CITY OF ALBUQUERQUE

Re: Mount Corp, 1201 Rio Grande Blvd NW
Permanent Certificate of Occupancy – Transportation Development
Architect's Stamp dated 06-14-10 (H13-D056)
Certification dated 10-14-10

Re: Mount Corp., 1201 Rio Grande Blvd NW, Traffic Circulation Layout
Architect's Stamp dated 06-14-10 (H13-D056)

From: Metro, Kristal D.
Sent: Wednesday, June 16, 2010 4:37 PM
To: 'tyson@efarchitects.com'
Subject: Mount Corp. at 1201 Rio Grande NW

G1.1

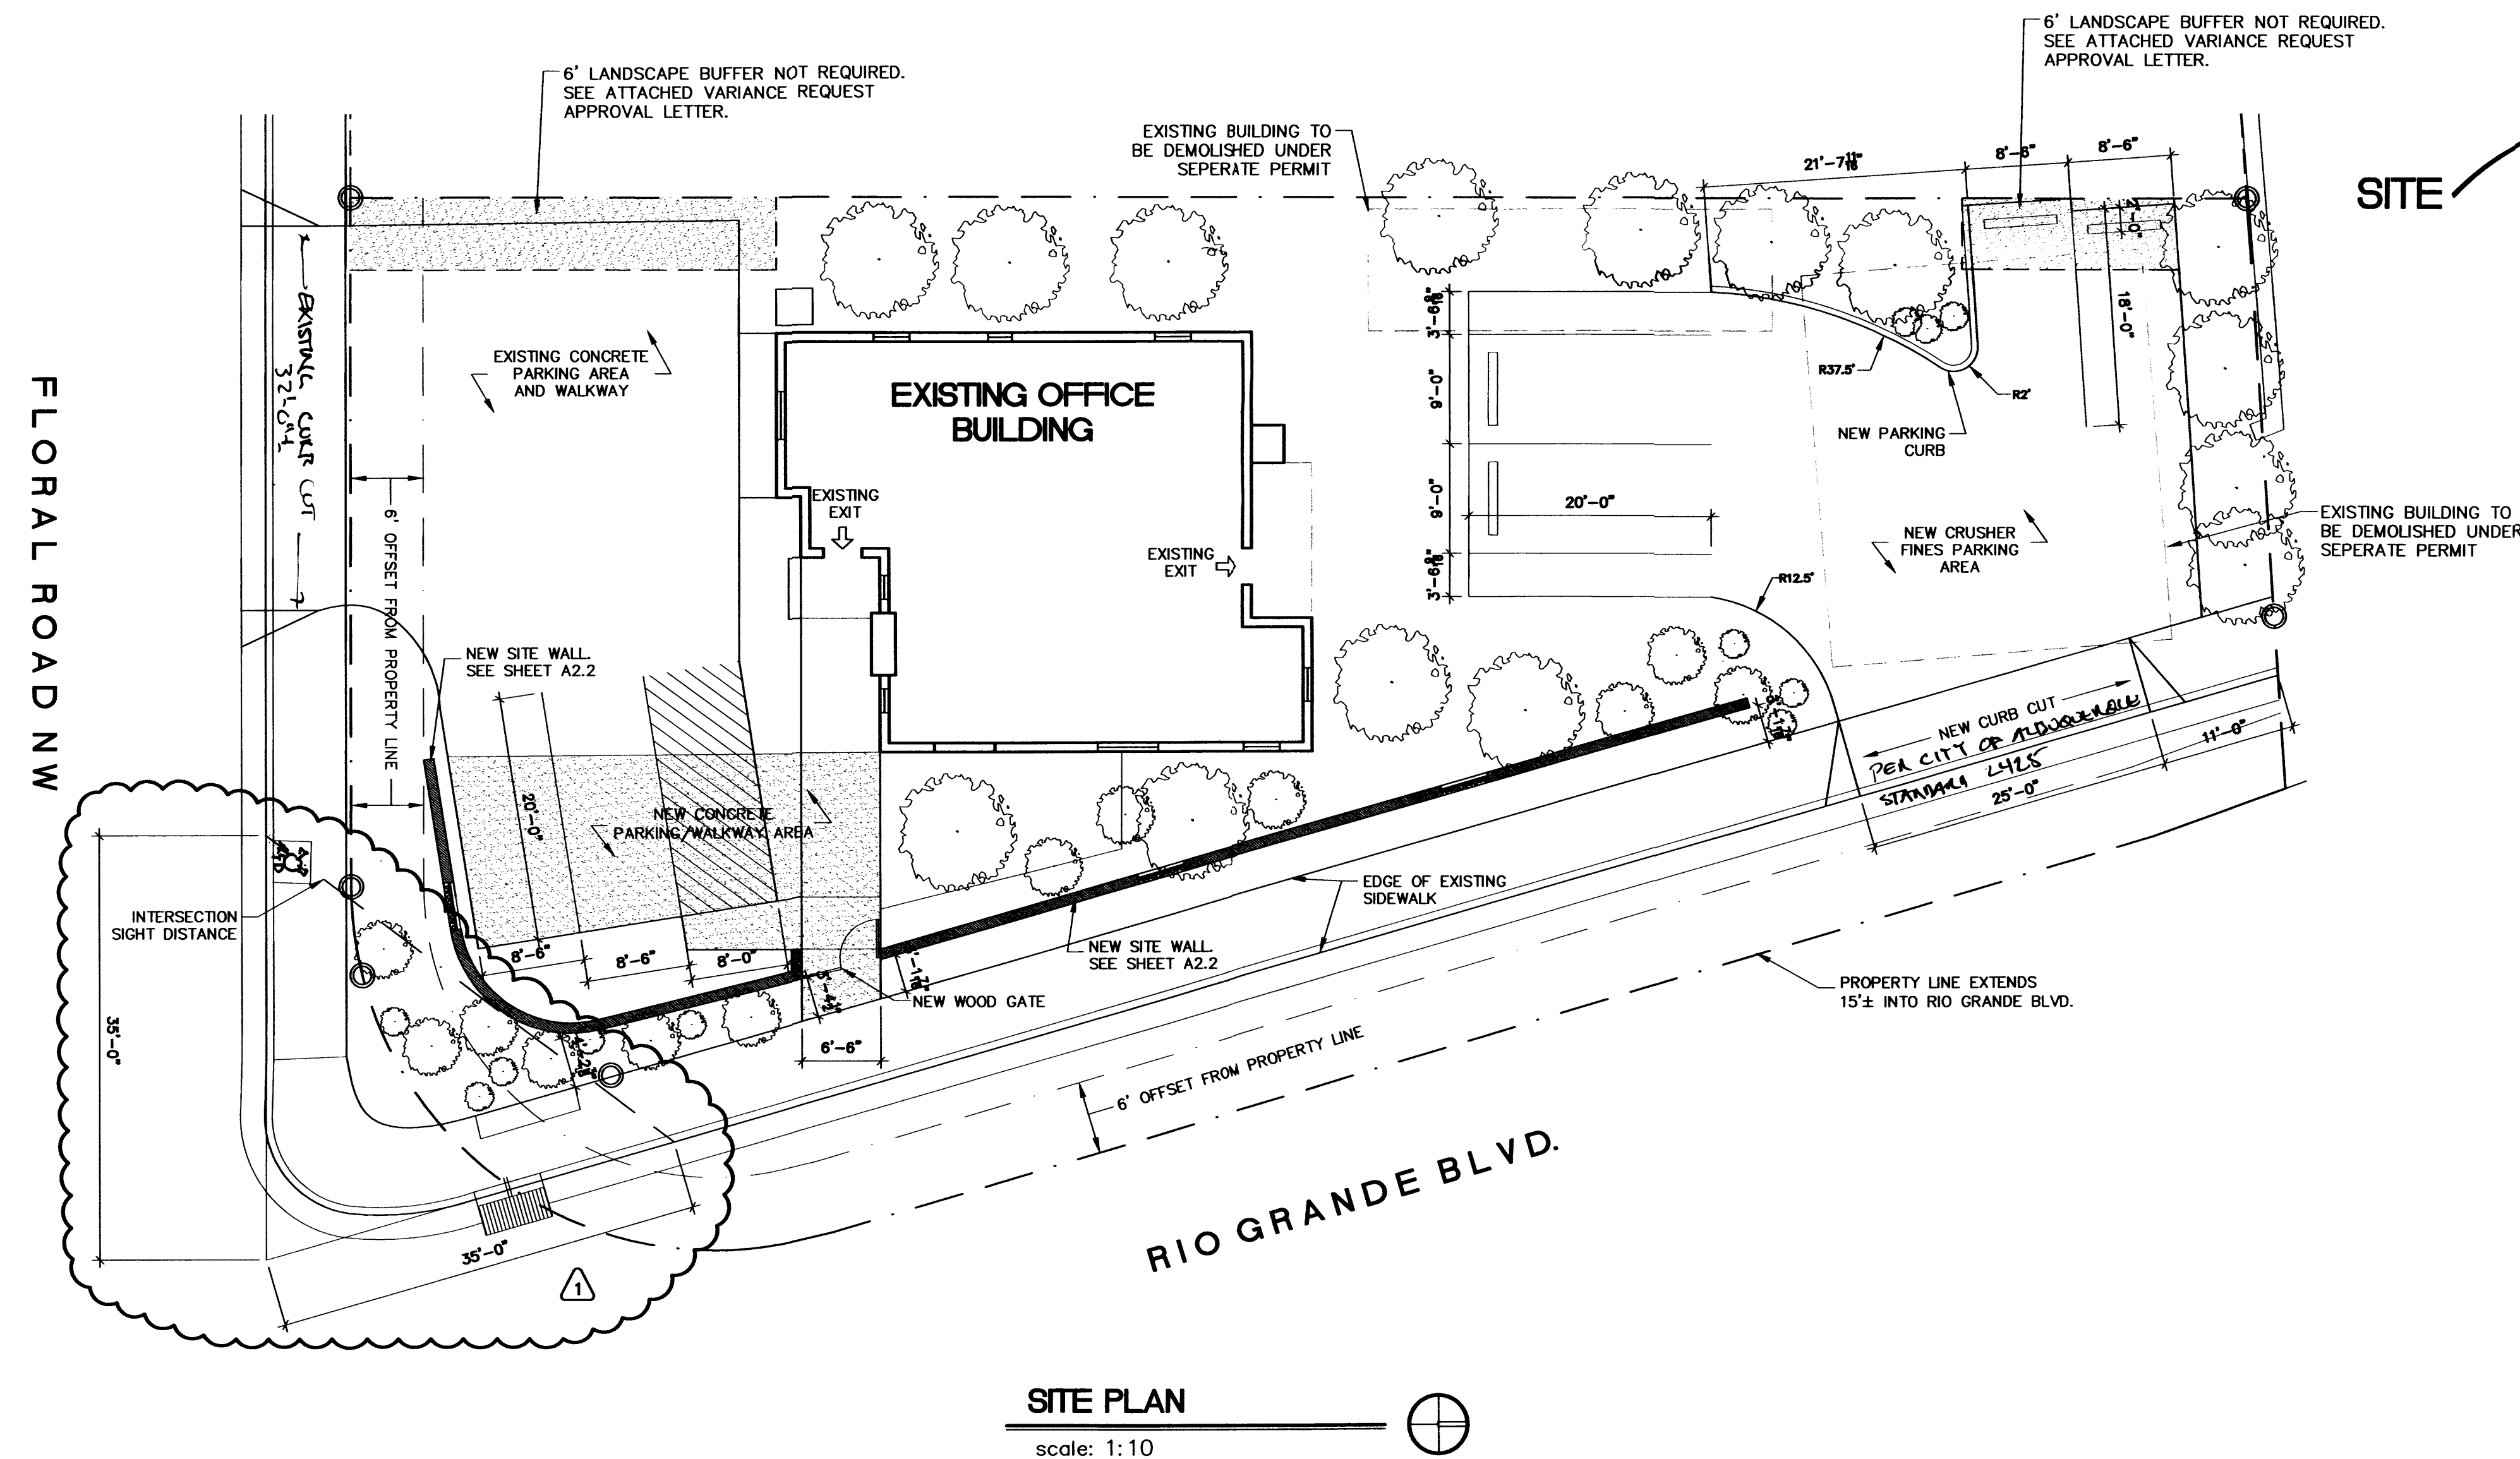
Tyson,
The highlighted area of the wall (see attachment) will need to be relocated or lowered to under 3 feet.
Thanks,
Kristal Metro, City of Albuquerque Transportation Development
